From: Sue Howell <Sue.Howell@arun.gov.uk>
Sent: 29 October 2020 17:21
To: Planning.Responses <Planning.Responses@arun.gov.uk>
Cc: Simon Davis <Simon.Davis@arun.gov.uk>
Subject: RE: Planning Consultation on: Y/98/20/PL

Response to Planning Application

From: Arun District Council Greenspace

Application ref: Y/98/20/PL

Figure 3: Current proposal for
75 homes

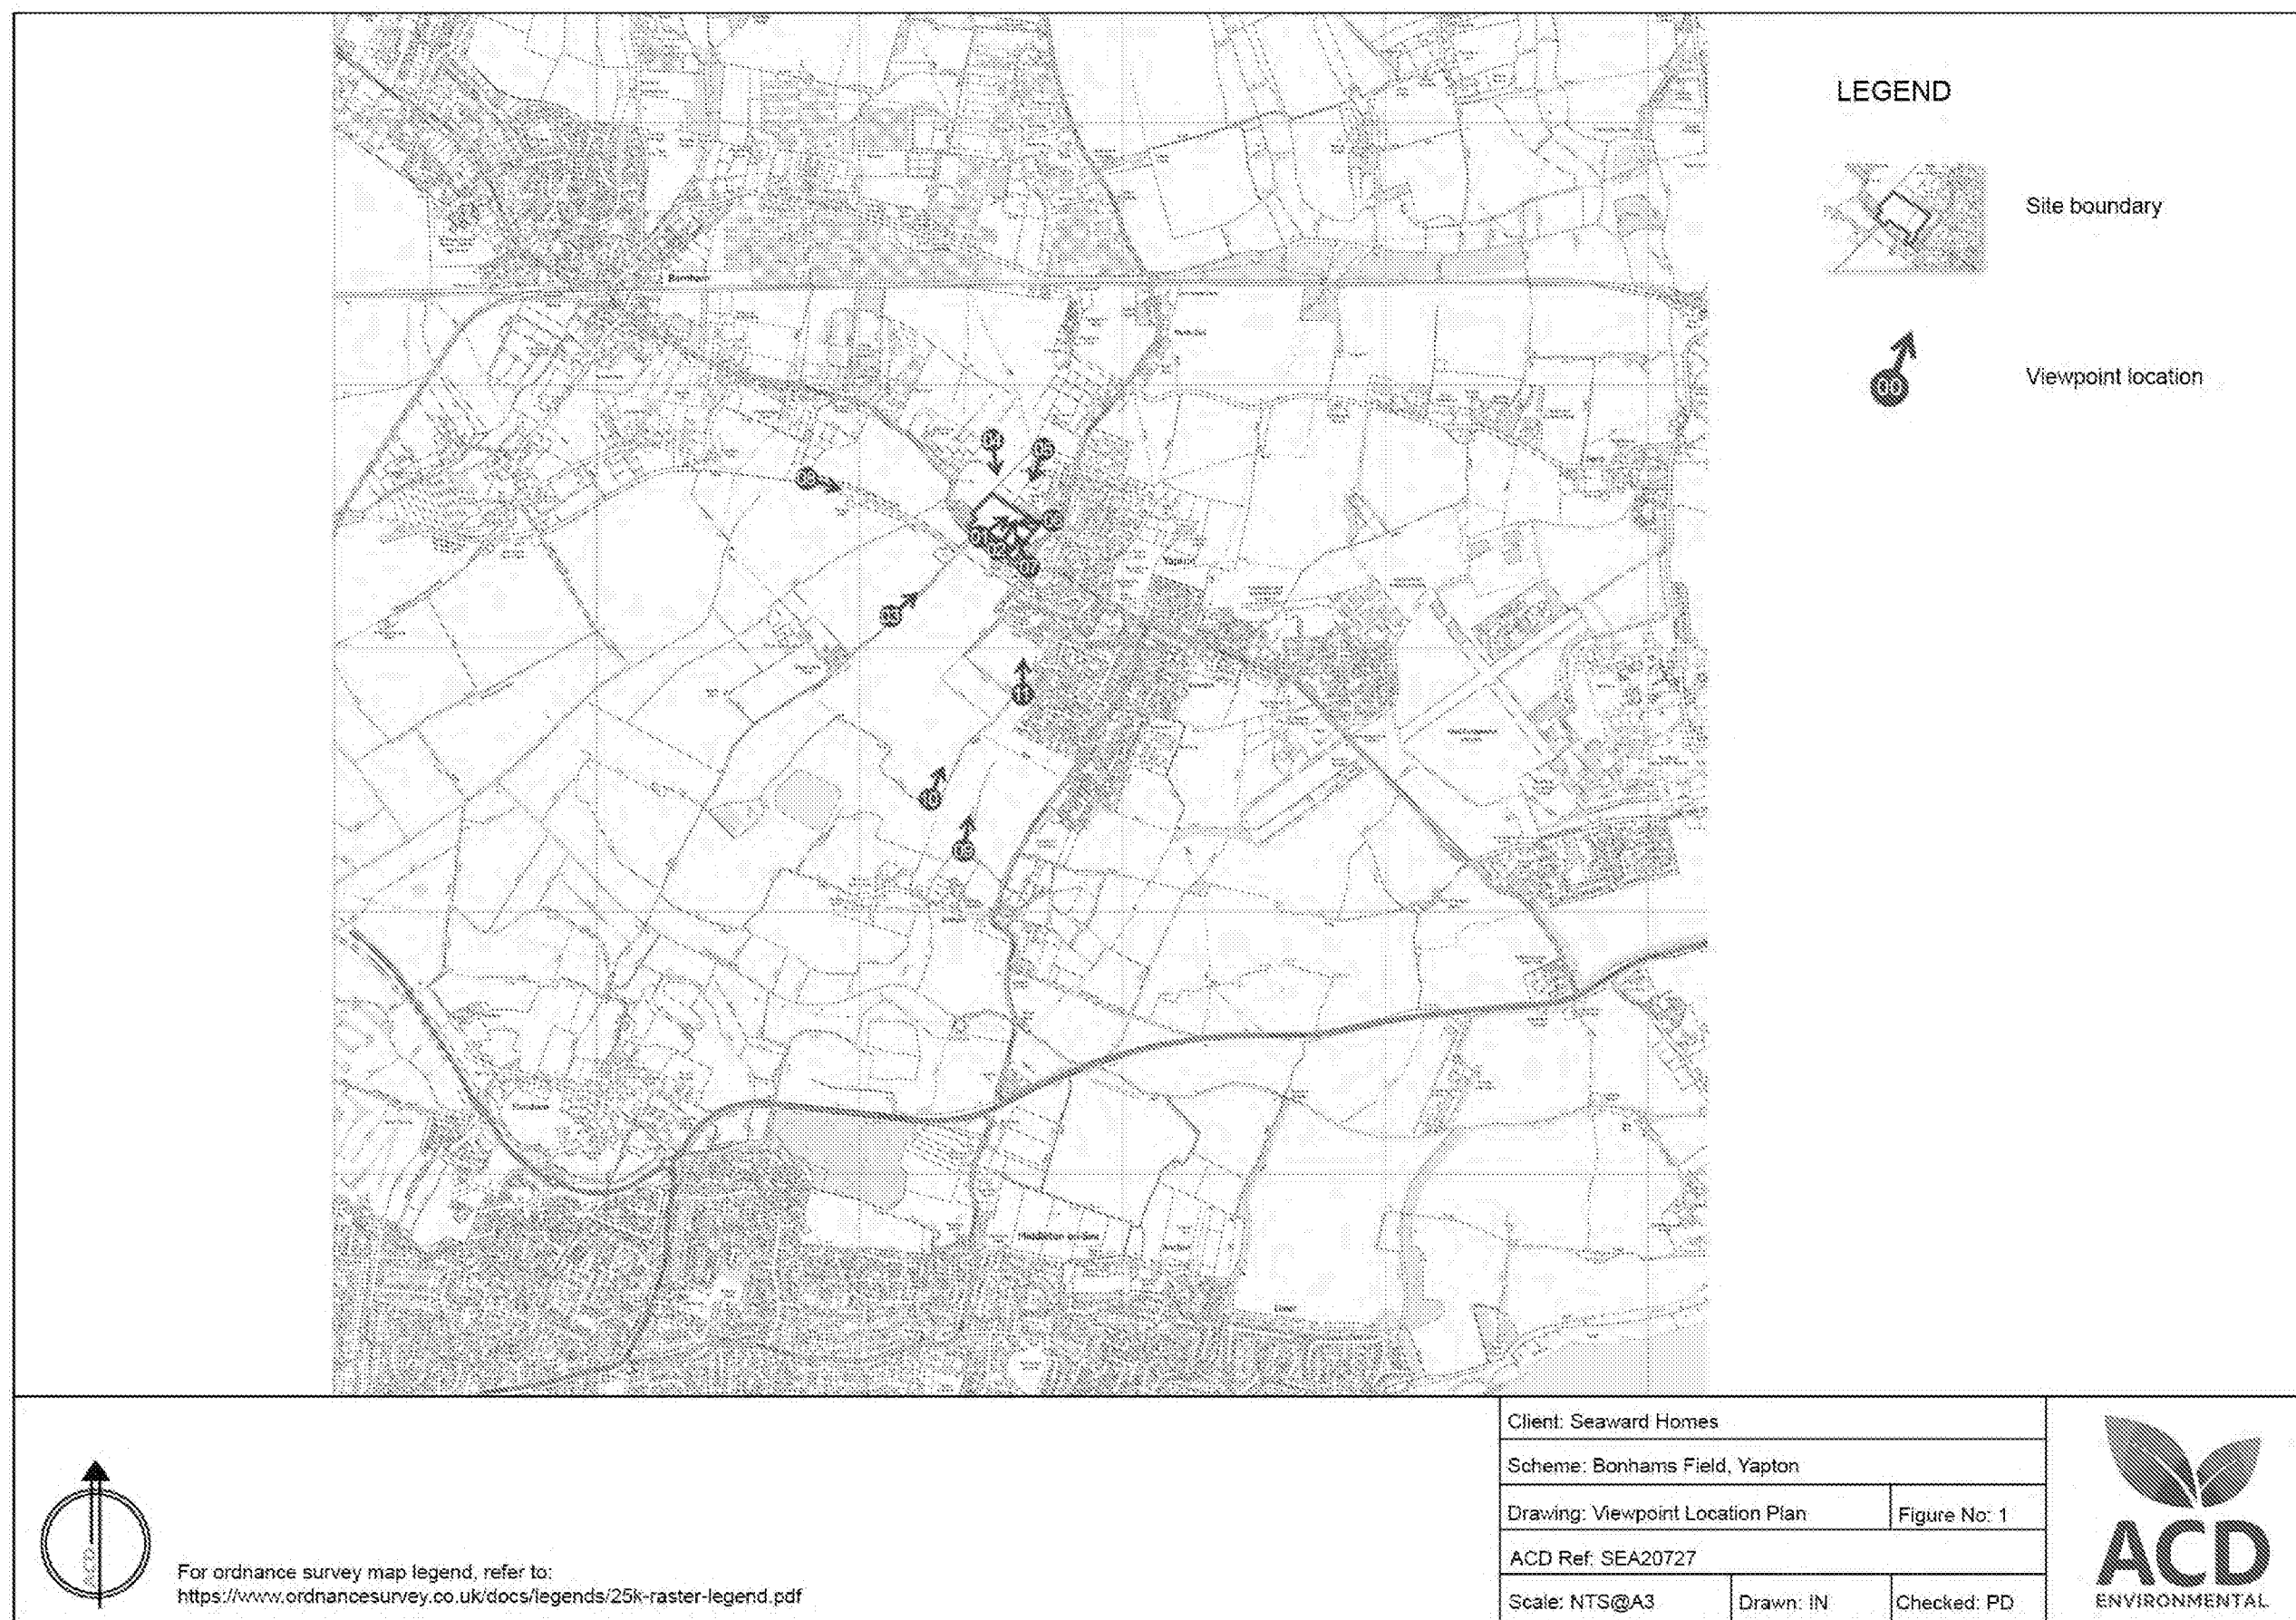
I would advise that the 75no dwelling proposal looks very cramped and over developed, particularly in the north/west portion of the site which now accommodates many of the smaller additional units. The proposals presented in application Y/98/20/PL appear detrimental in design layout to those approved in outline Y/1/17/OUT where I reference the layout plans submitted at that time and my comments of 16/05/17.
